**Response to Planning application from Hertfordshire County Council (T and CP GDP Order 2015)**

District ref: 6/2022/0374/COND  
HCC ref: WH/11165/2022  
HCC received: 24 February 2022  
Area manager: Matthew Armstrong  
Case officer: Steven Knight

CAMPUS WEST THE CAMPUS WELWYN GARDEN CITY AL8 6BX

Submission of details pursuant to condition 1 (Construction Traffic Management Plan), 2 (full site survey), 3 (detailed surface water drainage scheme), 4 (landscape and biodiversity plan), 5 (arboricultural method statement), 6 (updated remediation scheme), 7 (noisy works and ancillary operations) on planning application 6/2021/2207/MAJ

The tracking for the extended HGV (20.5 m) illustrates the Vehicle will clash with the existing traffic island. As the traffic island falls outside the site demise BGL of requested that the island is modified in a temporary state and this works are carried out as part of the S278 works.

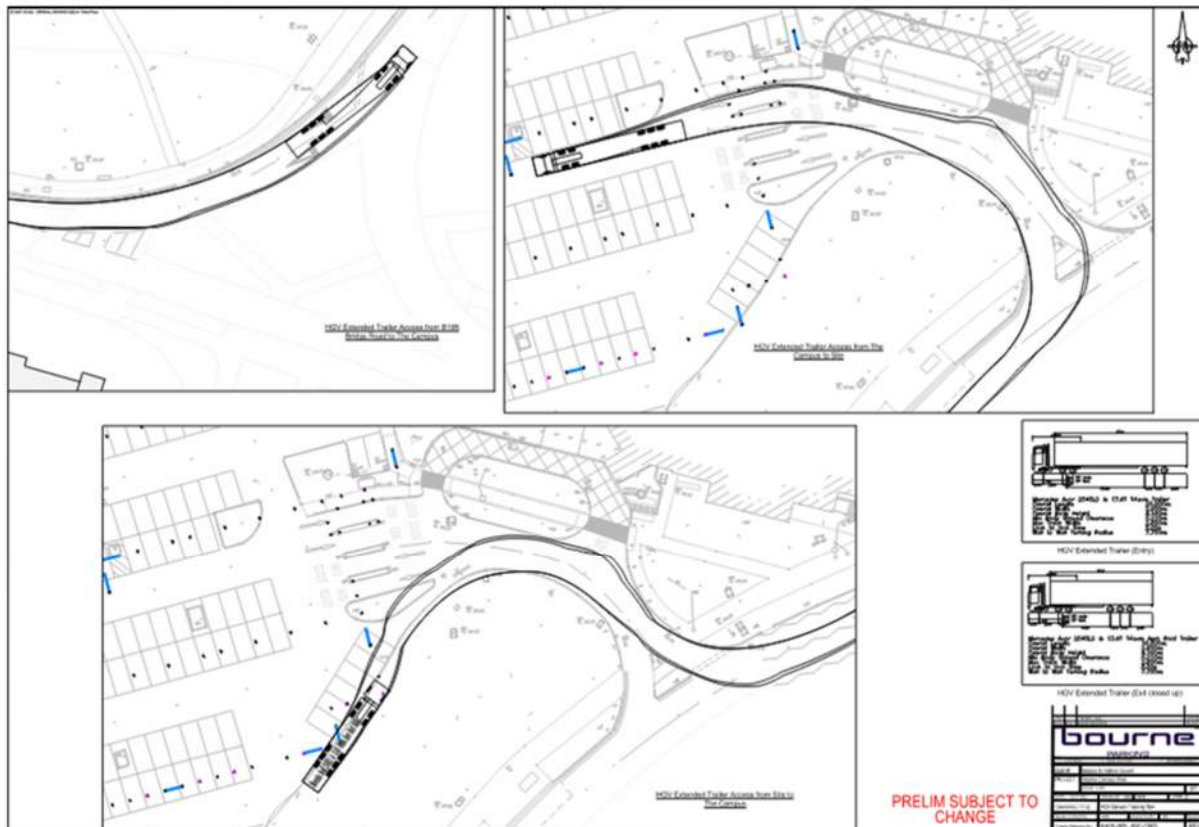
Vehicle swept path analysis has been provided for large vans, fire tender, mobile cranes and 20.5m HGVs. The plan proposes the temporary removal of the central island to allow access for HGVs. However, the island provides a useful refuge for pedestrians crossing the access road so thought should be given to how pedestrian safety can be maintained. Warning signs would be required at a minimum. The suggestion that this could be included within the S278 agreement should be carefully considered as it would require the S278 works to be approved and undertaken before works commence.

The swept path diagrams also show that HGVs will overrun the grass verge on both sides of the access road, although it is difficult to confirm the extent of this from the screenshots provided. There are large trees on both sides that are very close to the kerb line, but these don't appear to be shown of the swept path diagrams. It also seems likely that the canopies of these trees may be lower than the height of a lorry.

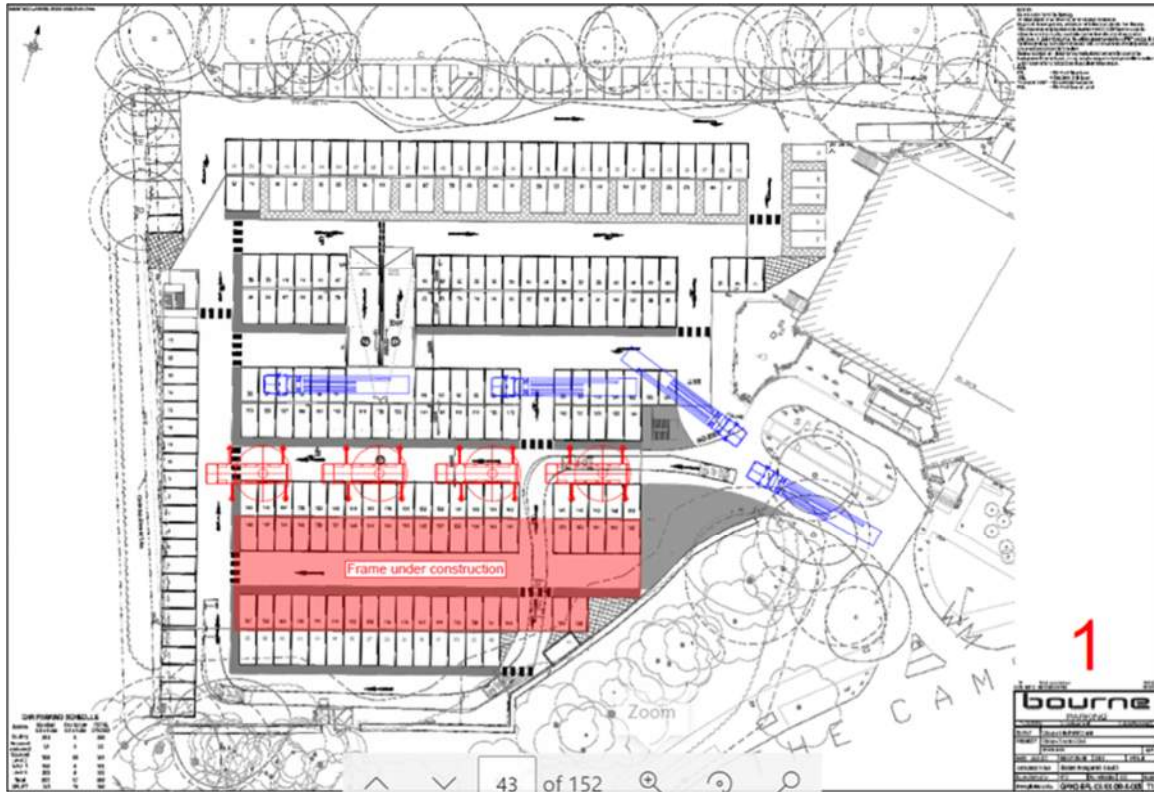
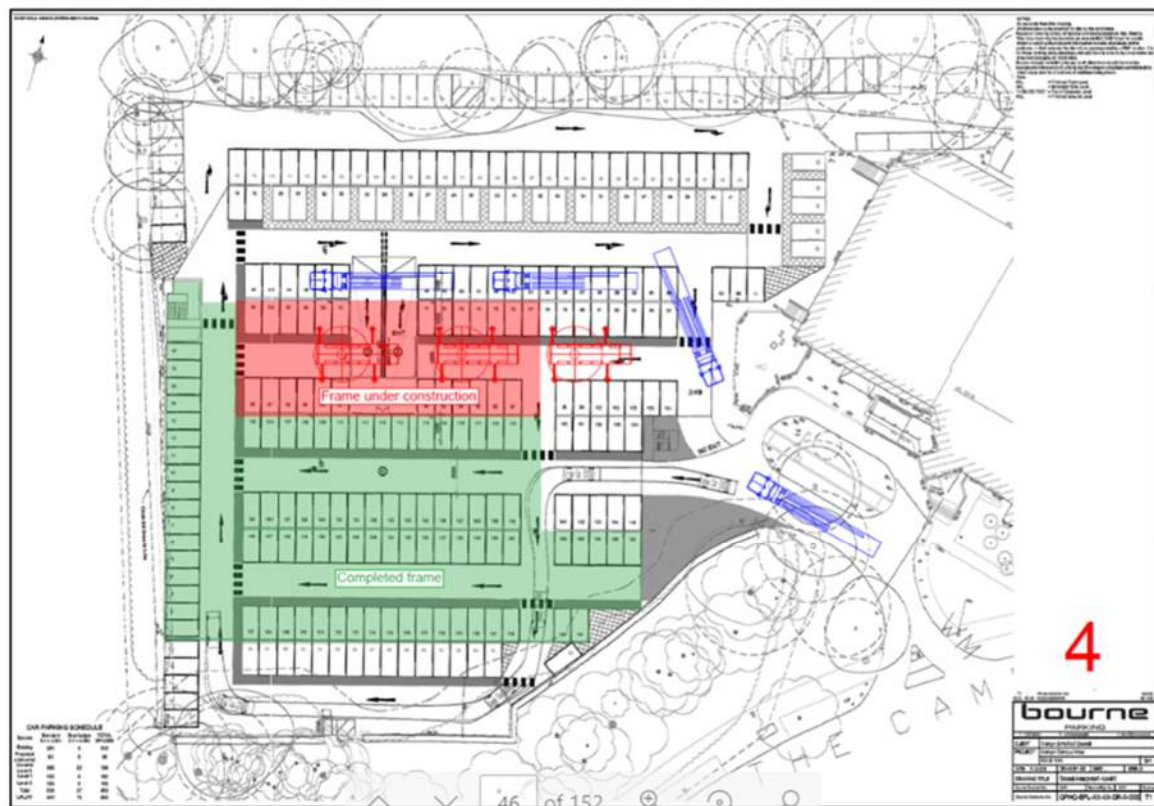
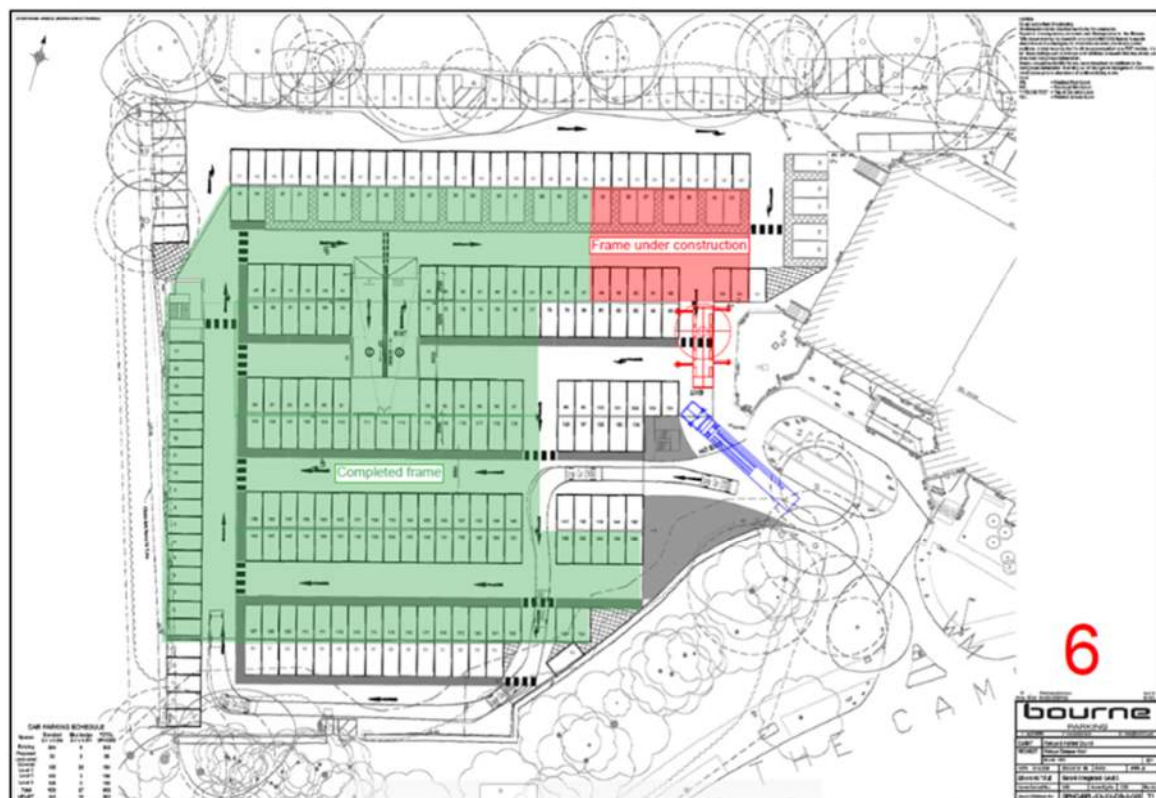
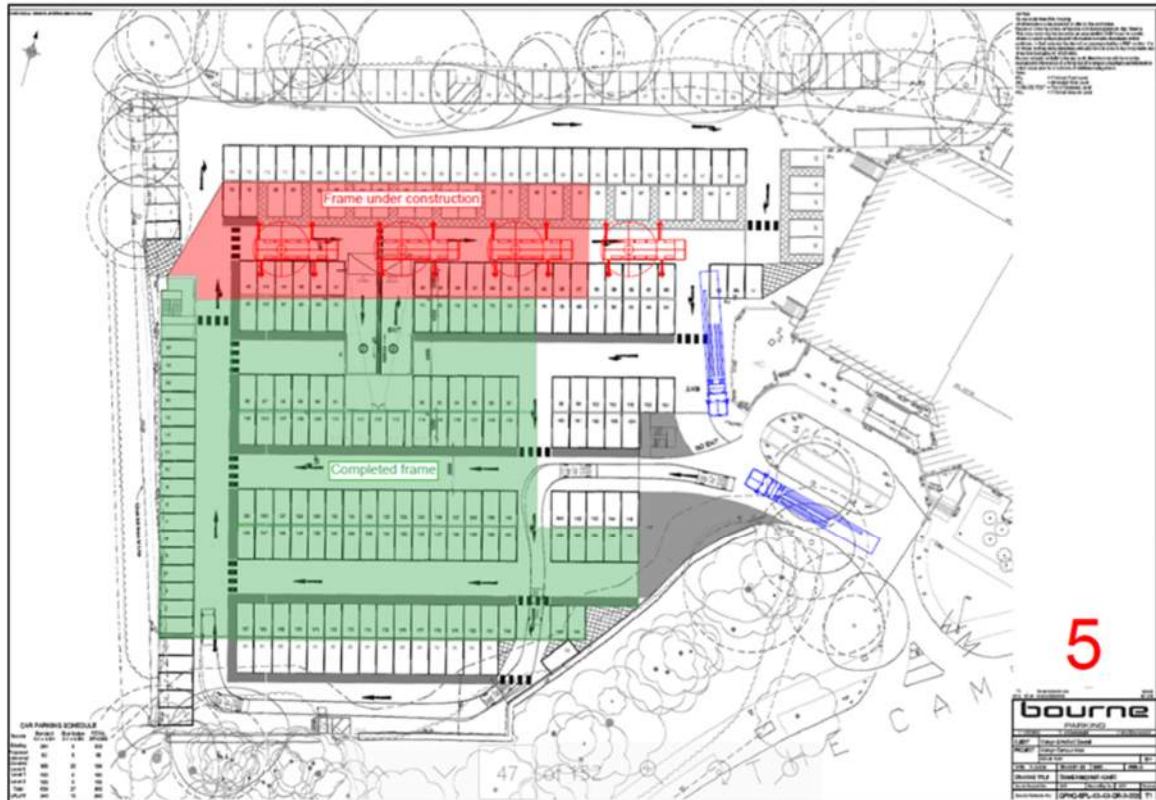
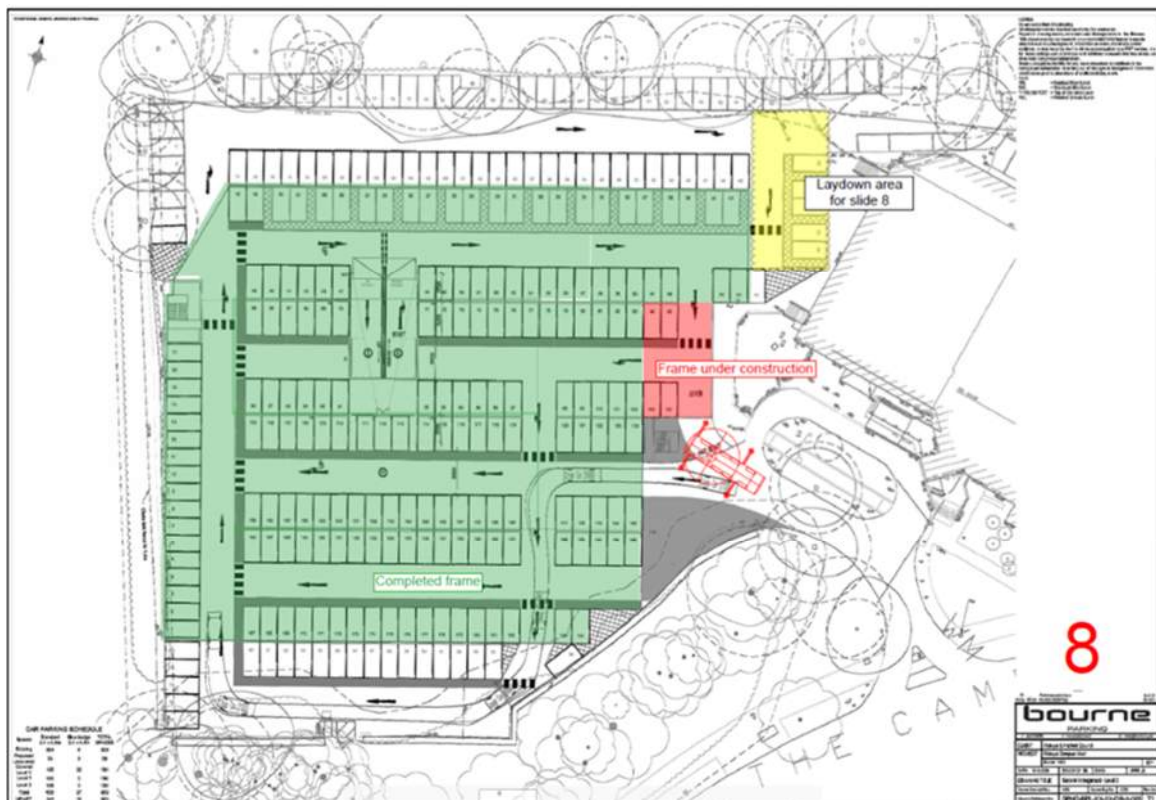
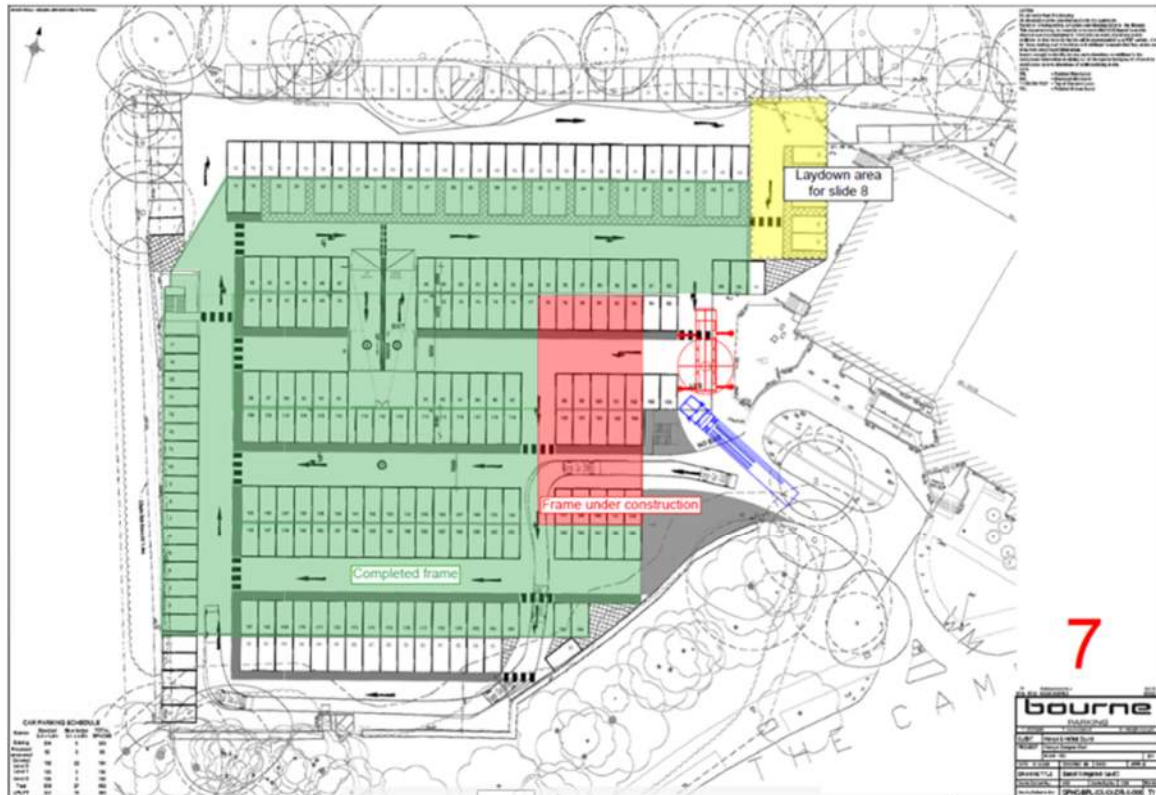
The plan divides the construction into eight phases and shows the on-site turning movements for each phase. It is particularly concerning that phases 7 and 8 (and possibly 6) will require lorries to reverse into the site from the highway. This should be reconsidered, but, if deemed absolutely necessary, a detailed traffic management plan would be required to be agreed with HCC's Network Management Team as part of this plan. The current reliance on banksmen only is not acceptable.
